DECISION DELEGATED TO HEAD OF PLANNING

Application No: H14-1219-25 **Applicant:** Mr & Mrs P Fox
Proposal: Change of use to 2 separate dwellings
Location: Sense 38 Church Street Pinchbeck
Terminal Date: 10th February 2026

| Client: MR. & MRS. P. FOX | Proposal: CHANGE OF USE TO TWO DWELLINGS AT 38 CHURCH STREET, PINCHBECK | Scale @ A3 1 : 250 | Title BLOCK PLAN - PARKING |

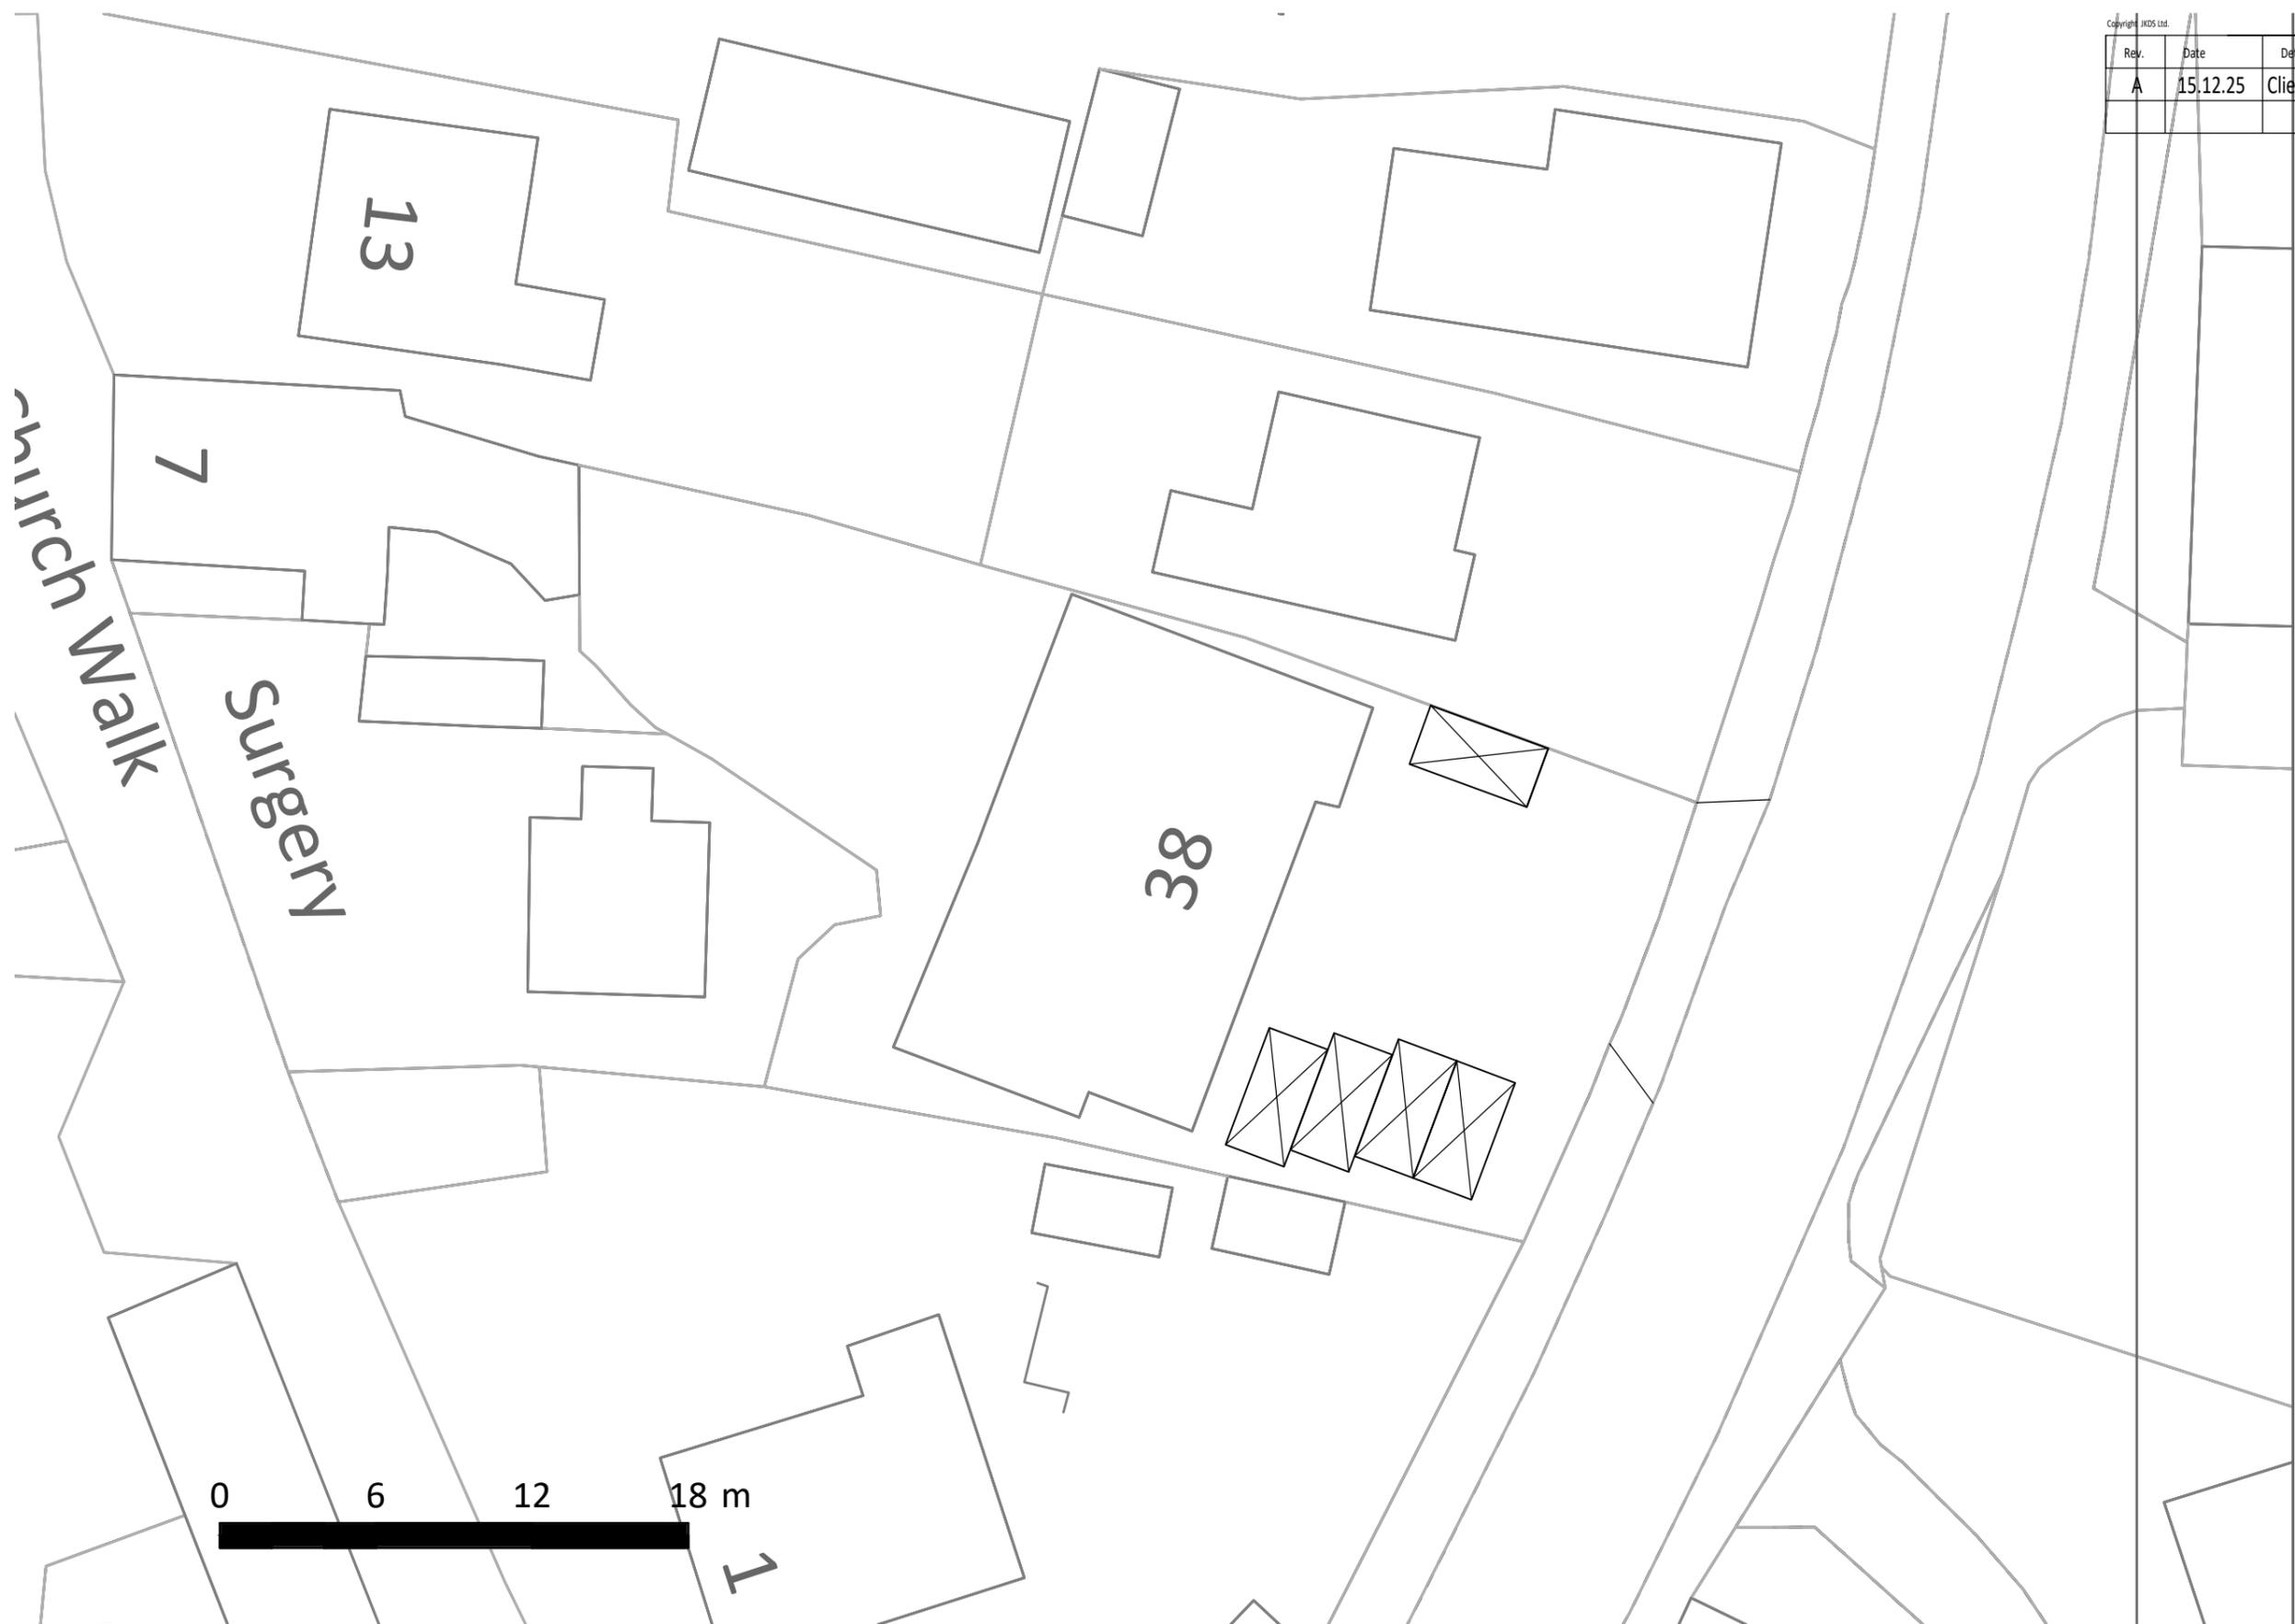
Request additional information to confirm whether same access is to be used for both dwellings and to detail the parking and turning on the block plan to show vehicles can leave in a forward gear. For the 3 bed house two parking spaces should be provided and for the 4 bed house three parking spaces should be provided.

PROPOSED ELEVATIONS

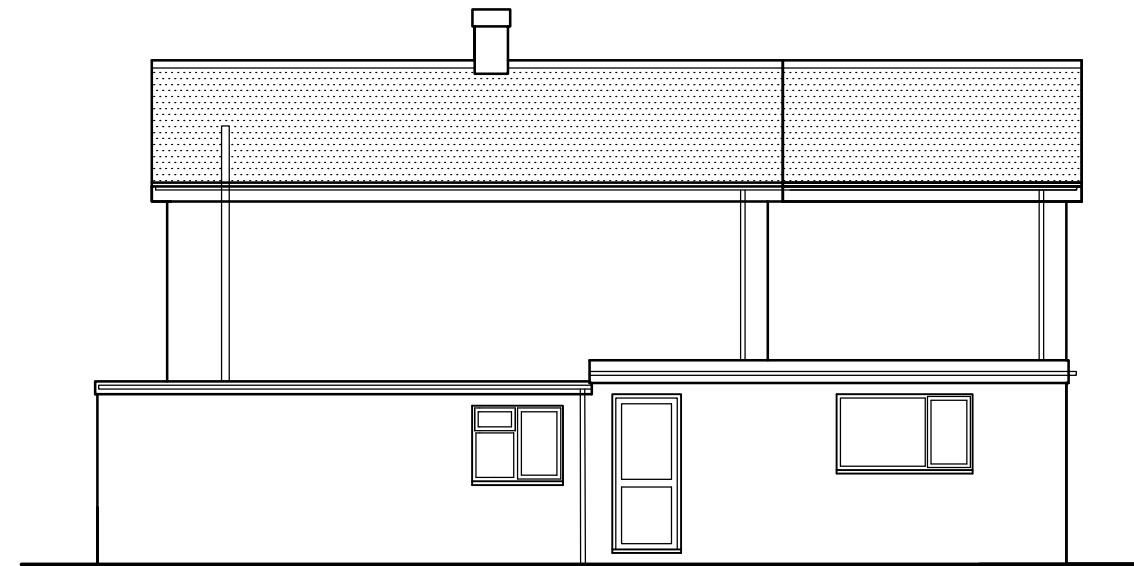
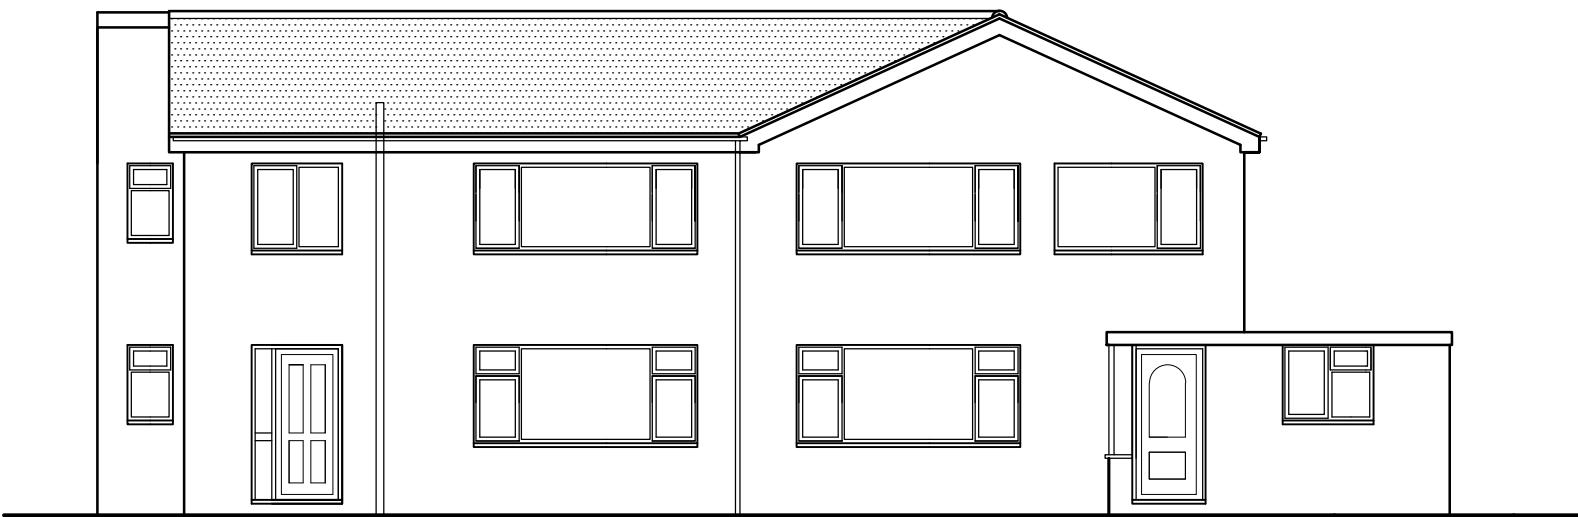
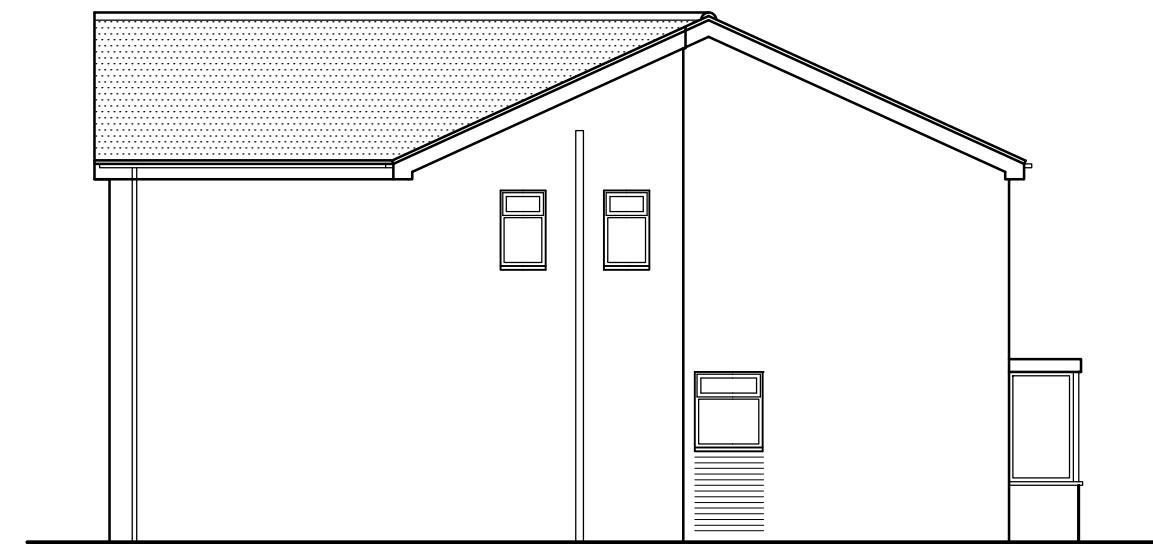
No detail of the proposed new fenestration is included. However, given the extensive use on site already, the proposed is assumed to be PVC units. Due to the extensive lawful use of such units on site already, it would be unreasonable to require the applicant to conform to a higher standard of fenestration. Recommend new fenestration matches the existing.
